6 November 2013

Name: K. R. HENDERSON
Address: 27 CALDER RD
DARLINGTON
2008 NSW

**Modification Request for the University of Sydney Abercrombie Precinct
Redevelopment: Application Number: MP07_0158 MOD 3**

Title
Scale
Date
Number
0 2 4
10 20m
Ground Floor Plan
MARK UP SET
1:200@A1
11.10.13
4001_DA02-D
© copyright nettleton tribe partnership pty ltd

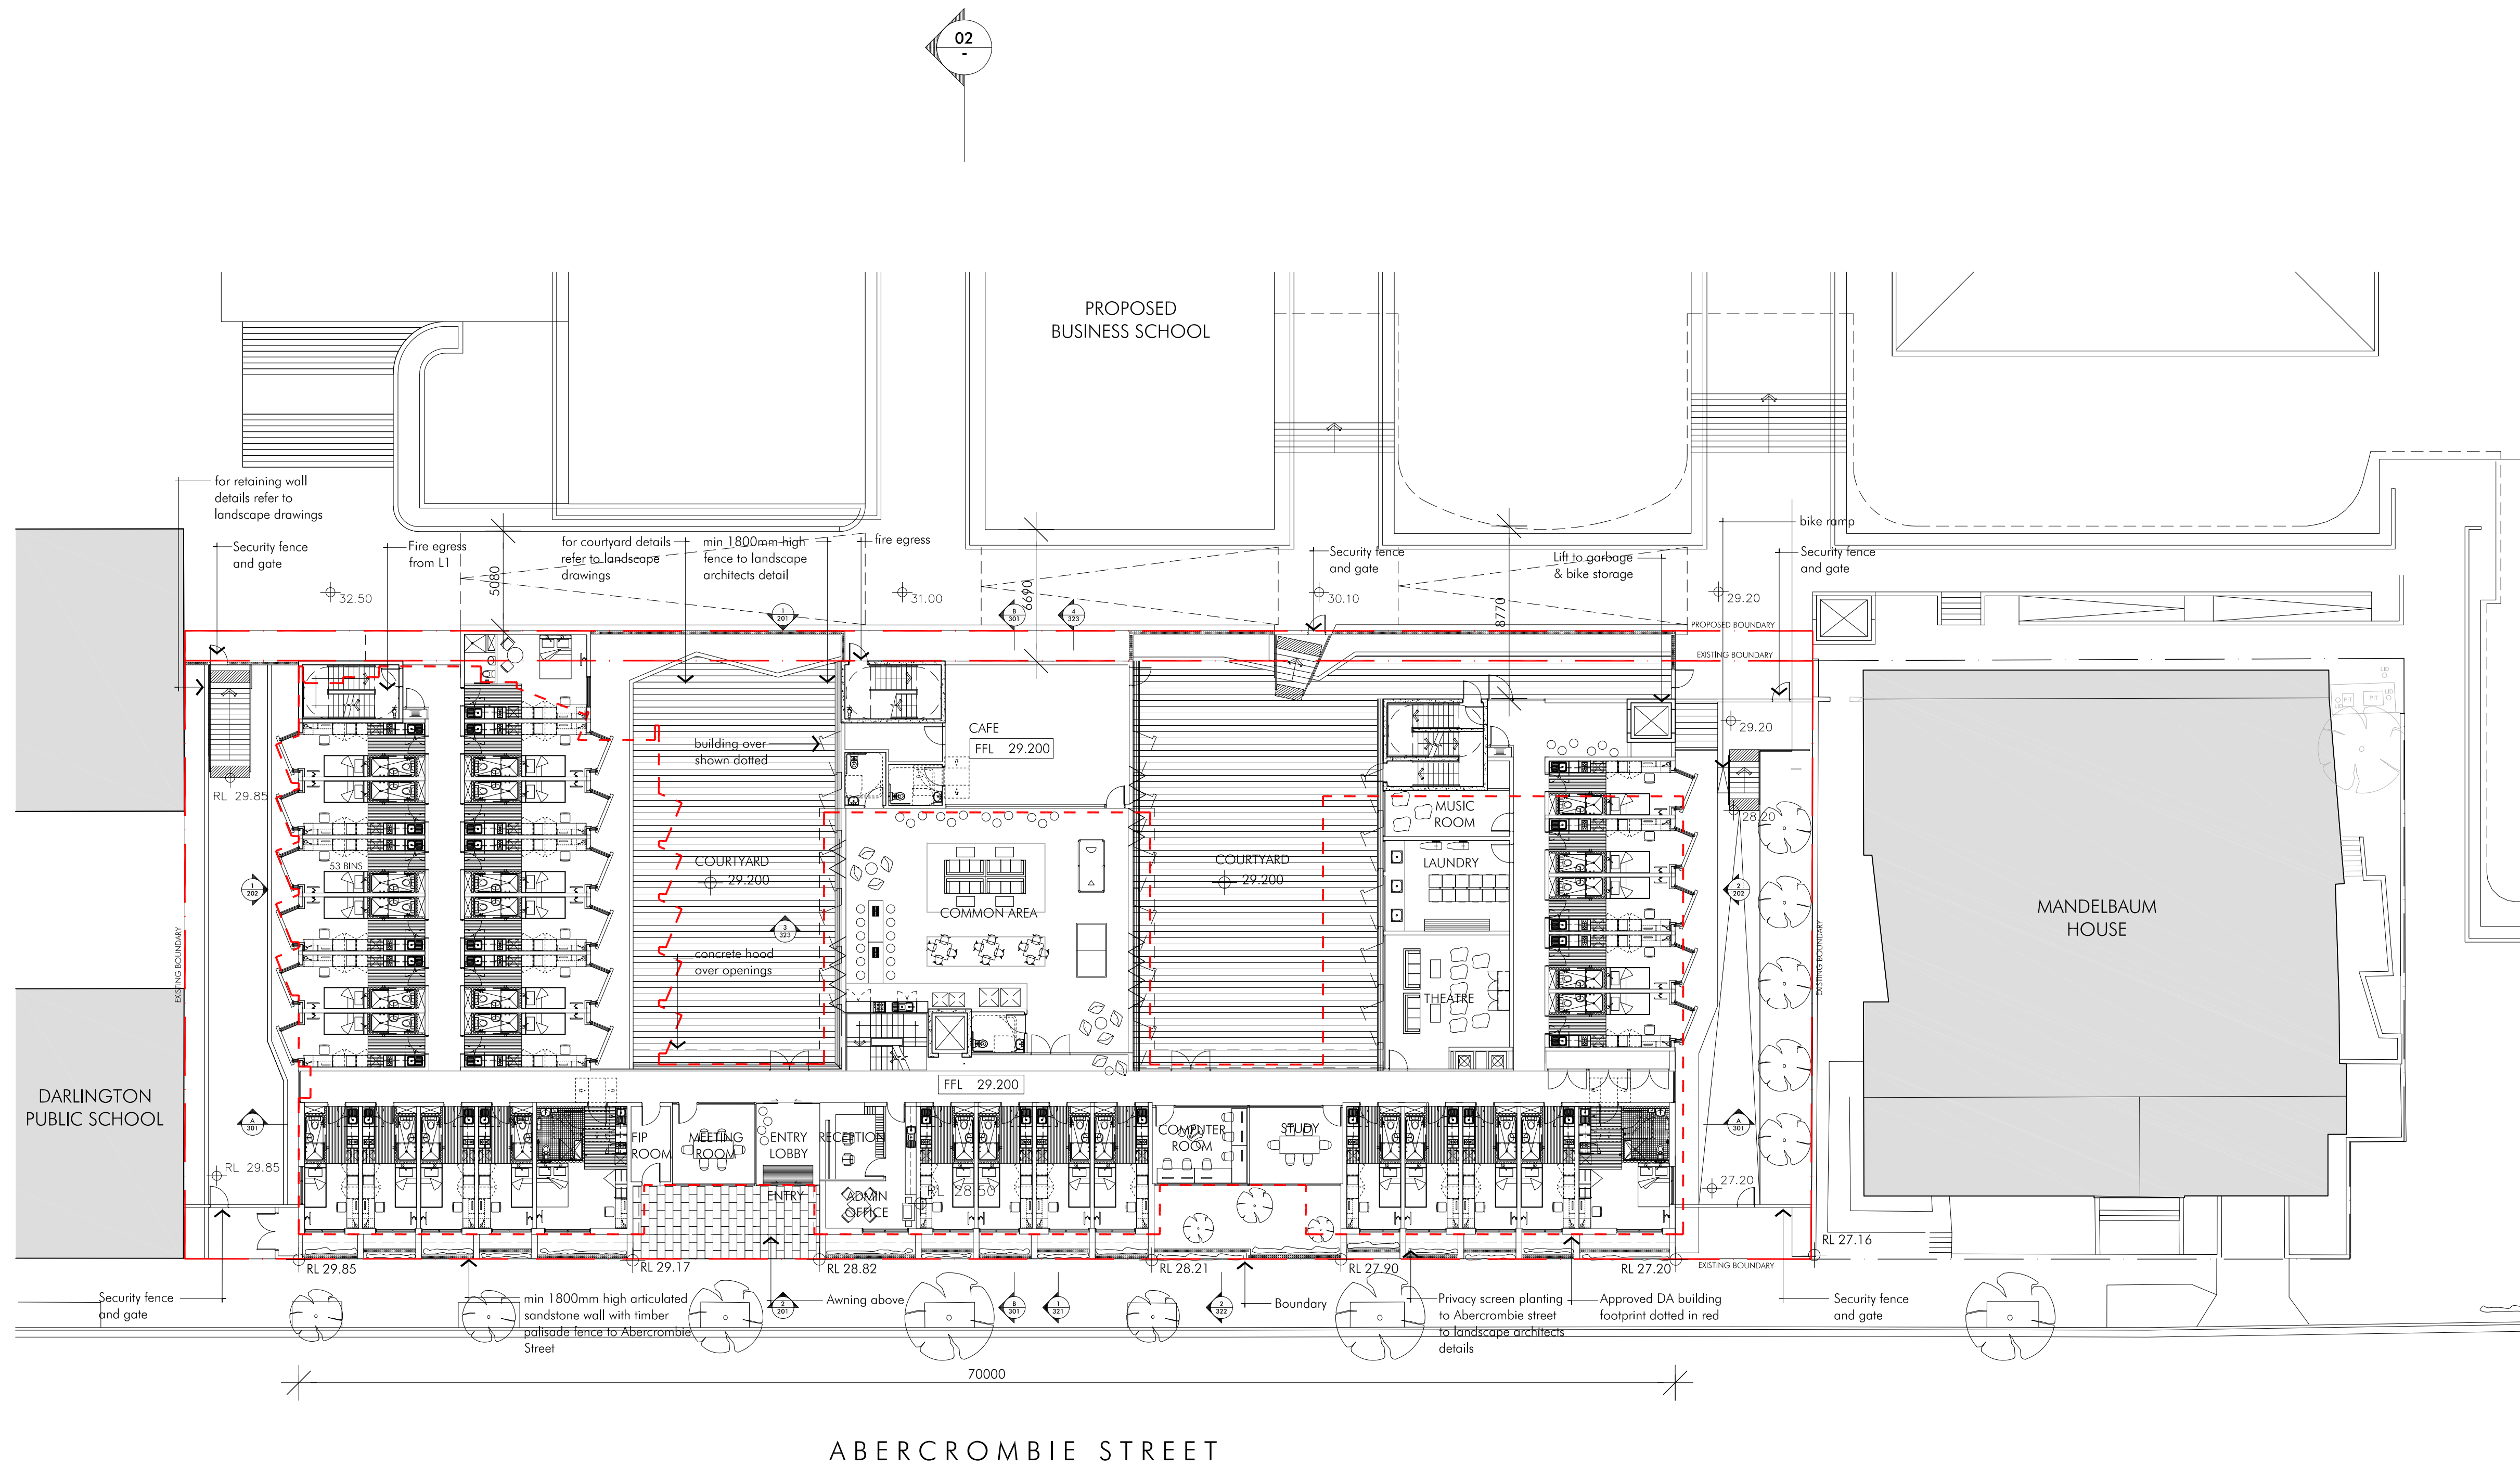
- The front of the Student Accommodation building should be built 2 metres back from the Abercrombie Street boundary. It should be set back from this boundary so that it is in line with Mandelbaum House as it was originally planned and presented to the community. The footprint of the buildings currently on the site, The Shepherd Centre and Boundary Lane Children's Centre, were built approximately 2 metres back from the Abercrombie Street boundary and align with Mandelbaum house. Therefore, the front footprint of the proposed Student Accommodation building should be the same as those buildings occupying the site at present and not be built up to the Abercrombie street boundary.

- The facade of the proposed Student Accommodation building does not reflect the heritage appearance of the Victorian terraces on Abercrombie Street as Mandelbaum House does. Therefore, it should be set back to allow for extensive vegetation and trees to be planted in front of the building on Abercrombie Street to help preserve the heritage streetscape and improve both the aesthetics and the environment of the street.
